From: Colin Sharpe
Sent: 13 November 2012 13:43
To: Jane Tucker
Subject: FW: 0959 Wooden Shed

From: simonstone [mailto:simonstonepc@talktalk.net]
Sent: 13 November 2012 13:41
To: Colin Sharpe
Subject: 0959 Wooden Shed

The Parish Council wishes to object to the above application on the following grounds :-

PROPOSED Storage Cabin scale 1:50 drwg. 2.
for M. & J. Unsworth 1. Caister Ave Whitefield
on land at Trapp Lane Simonstone

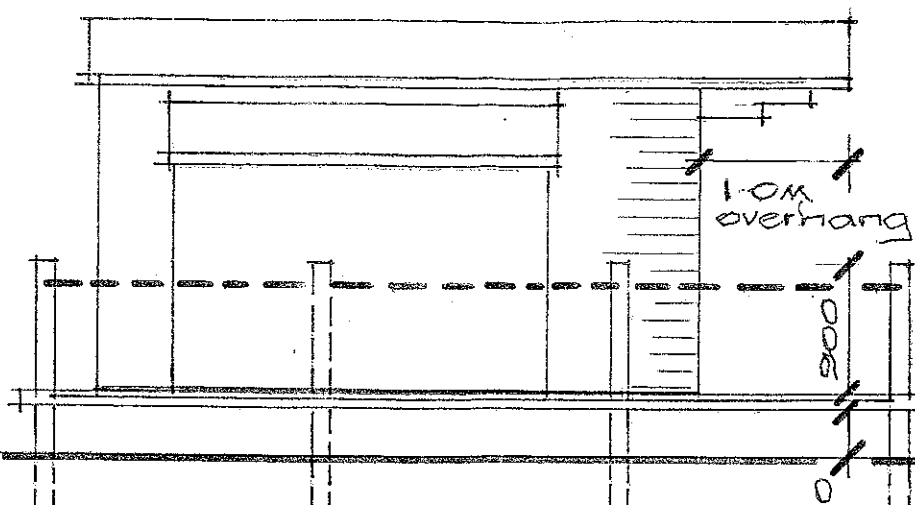
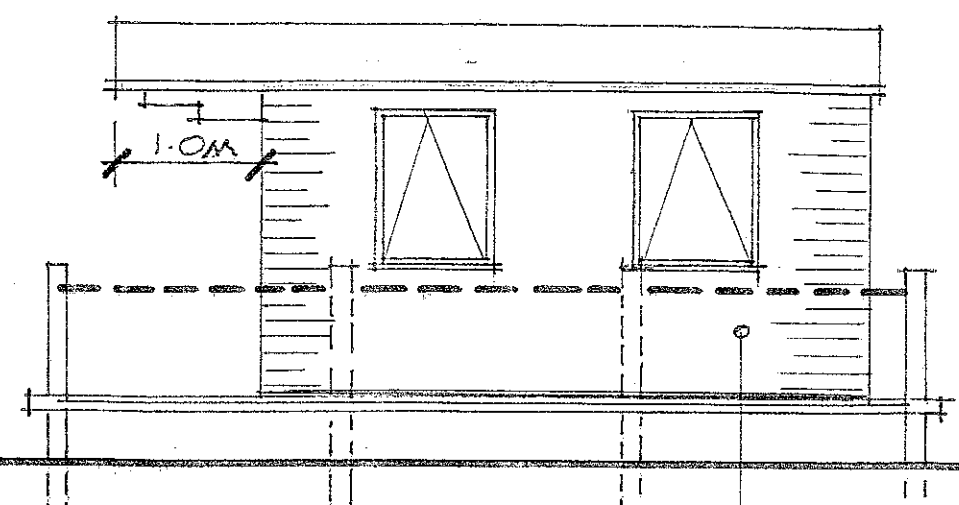
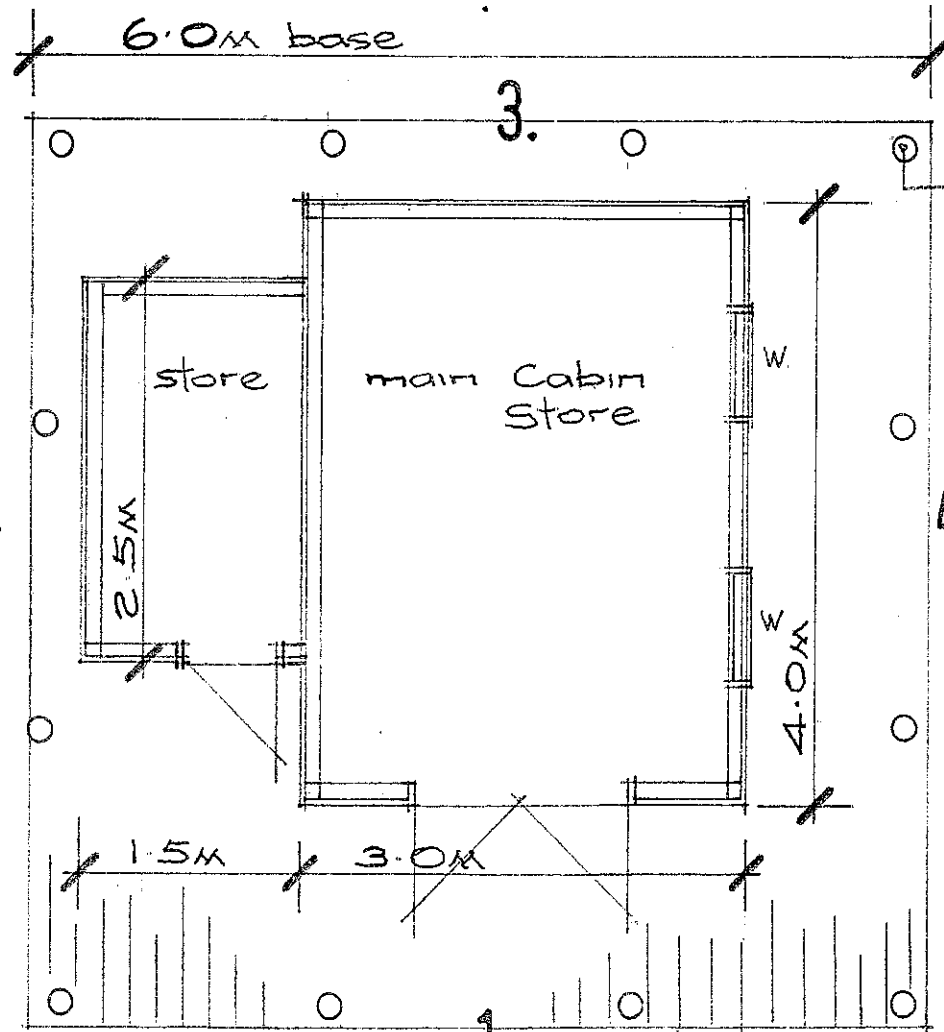
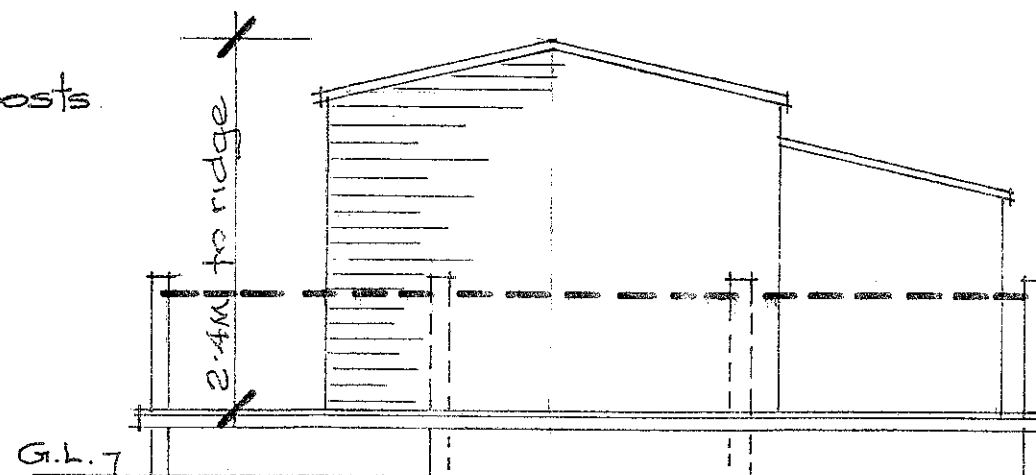
Looking at the plans for the shed, it seems to be rather large for such a small polytunnel. It is on agricultural land and has mainly been used for Cattle and sheep.
